DELEGATED DECISION TO DETERMINE PLANNING APPLICATIONS

Reference No: 2019/62/90213/E

Site Address: 119, Westfield Lane, Wyke, BD12 9LY

Description: Erection of single storey extensions, alterations and conversion of garage into living space

PROPOSED EXTN.

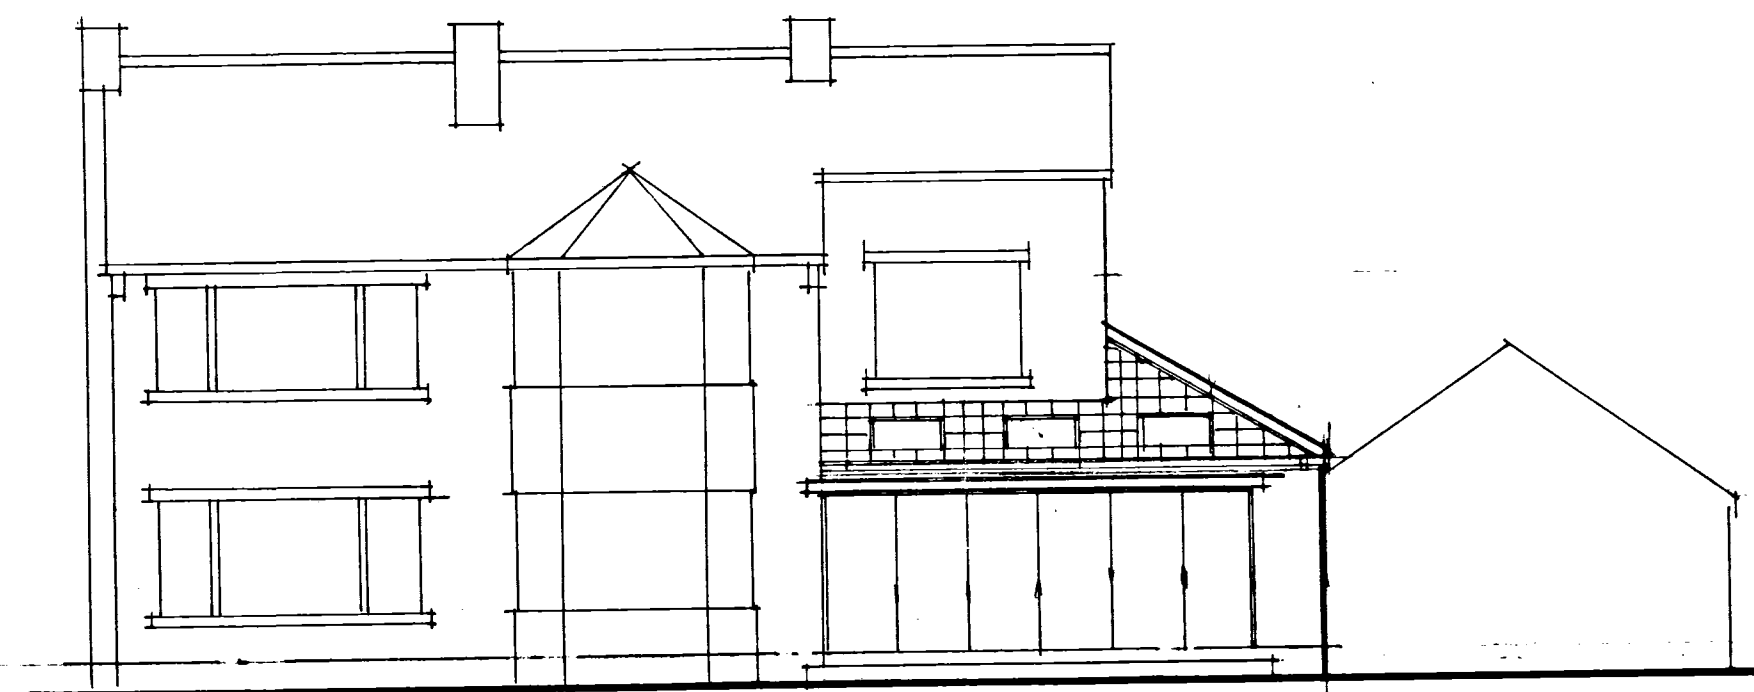
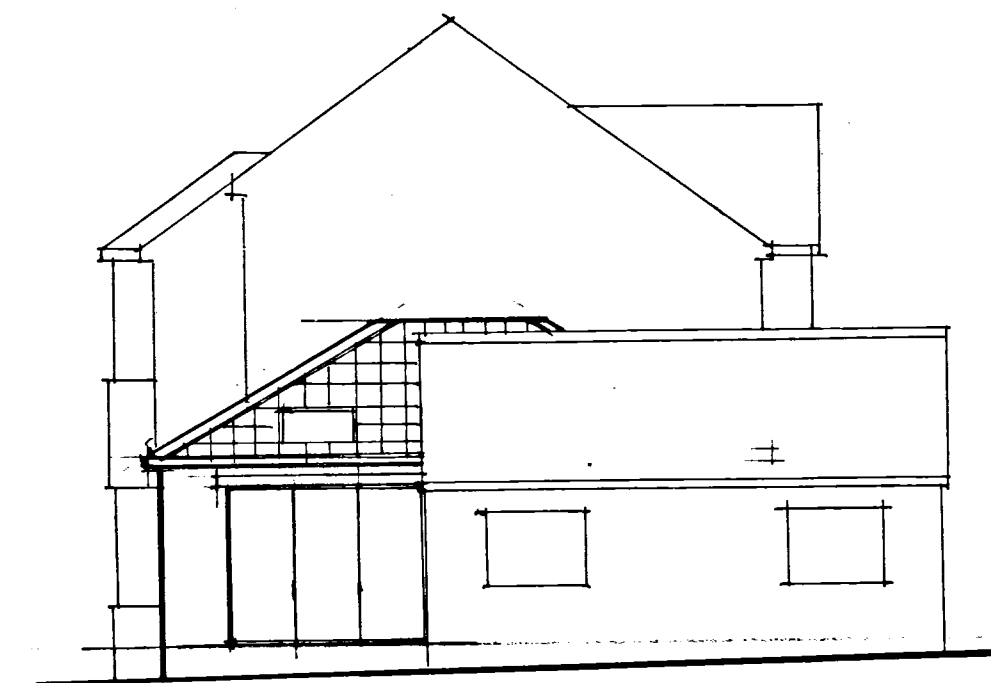
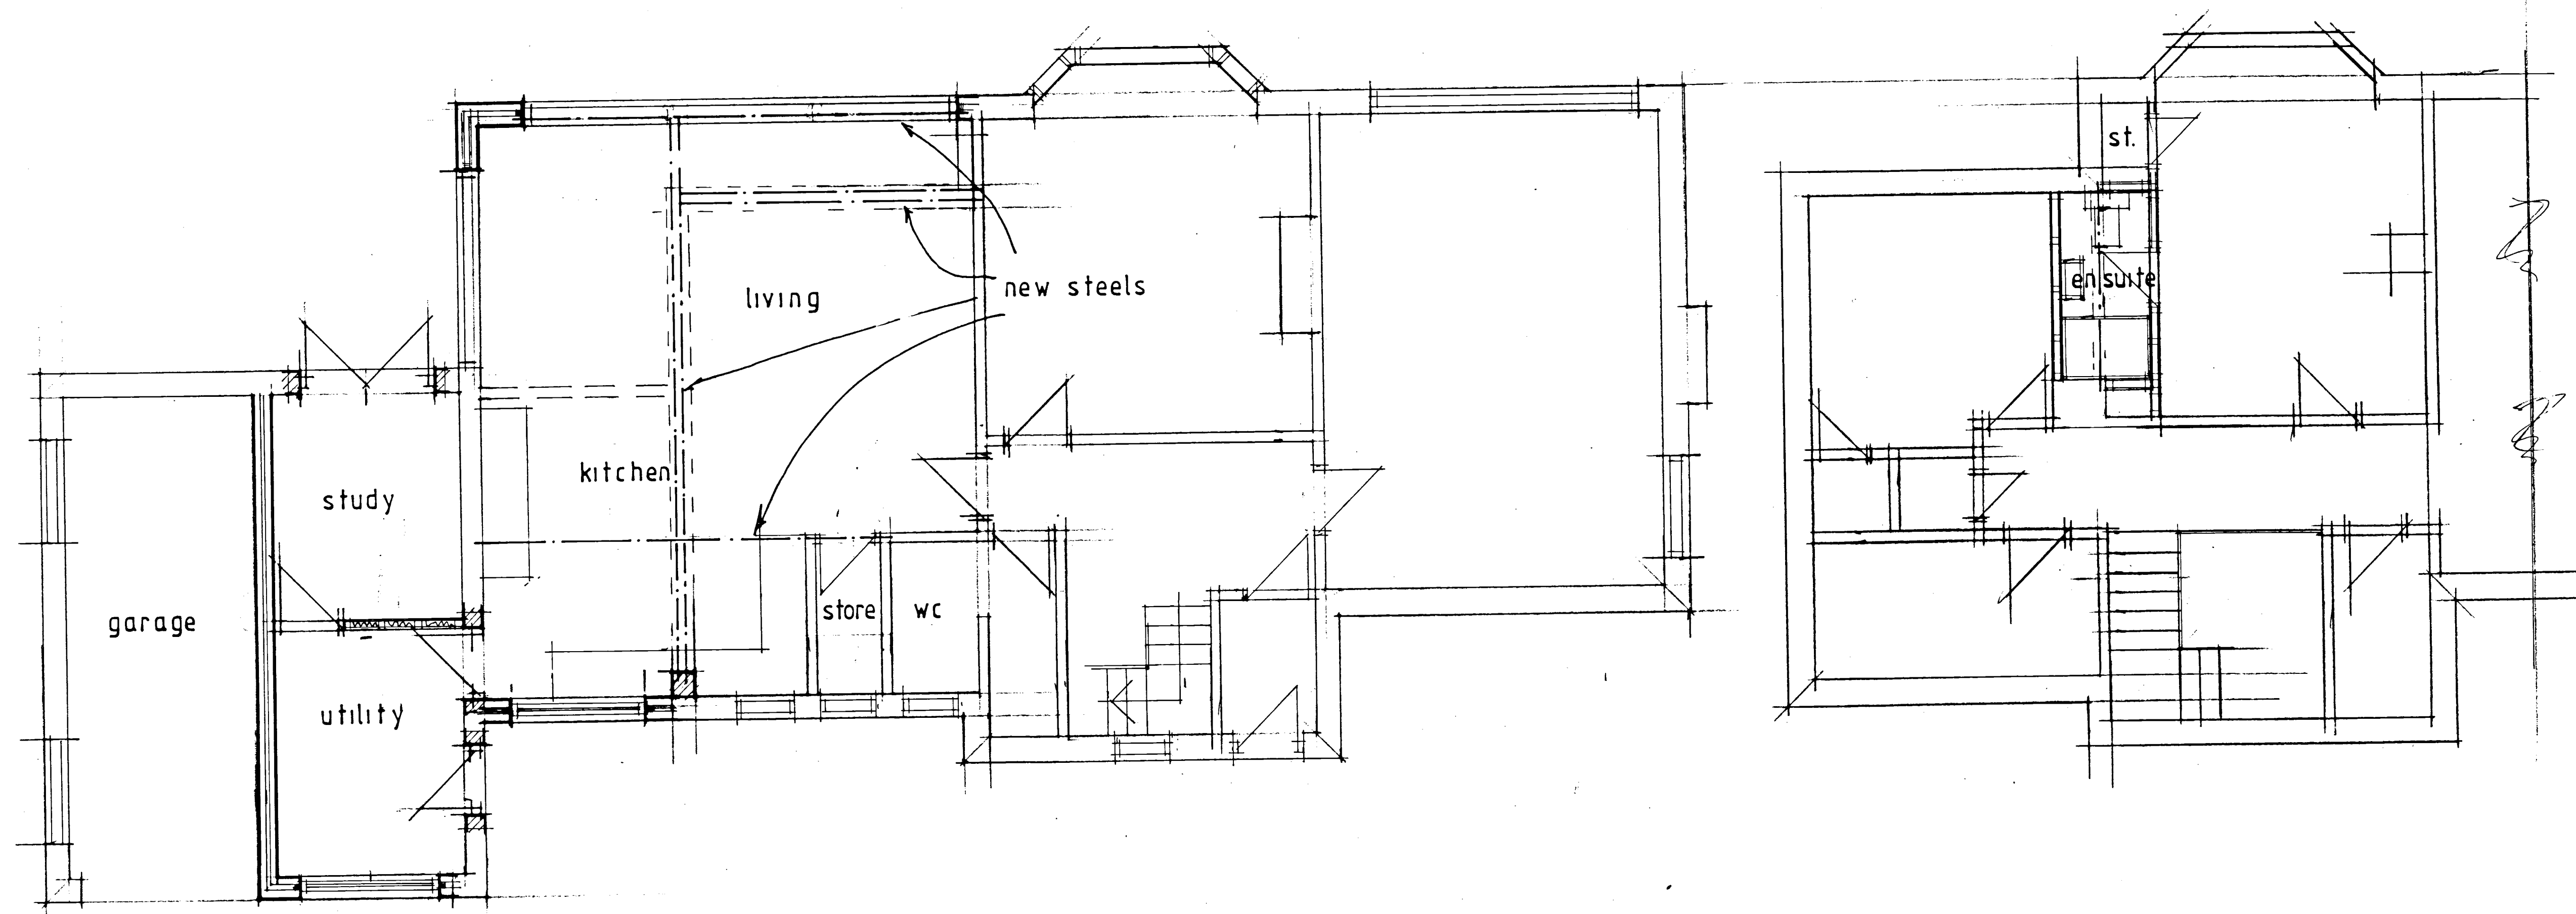
The officer entered discussions with the agent regarding a proposed opening not be shown on the south western elevation plan. An amended plan was received on the 06.03.19.

Nonetheless, it has been considered that there will be some impacts on overlooking, as the submitted plans show a large opening to be inserted into the south eastern facing side elevation. This has carefully been assessed, and due to their being sufficient boundary treatment in place in which will obscure some of the potential harm, on balance the impacts proposed can be supported.
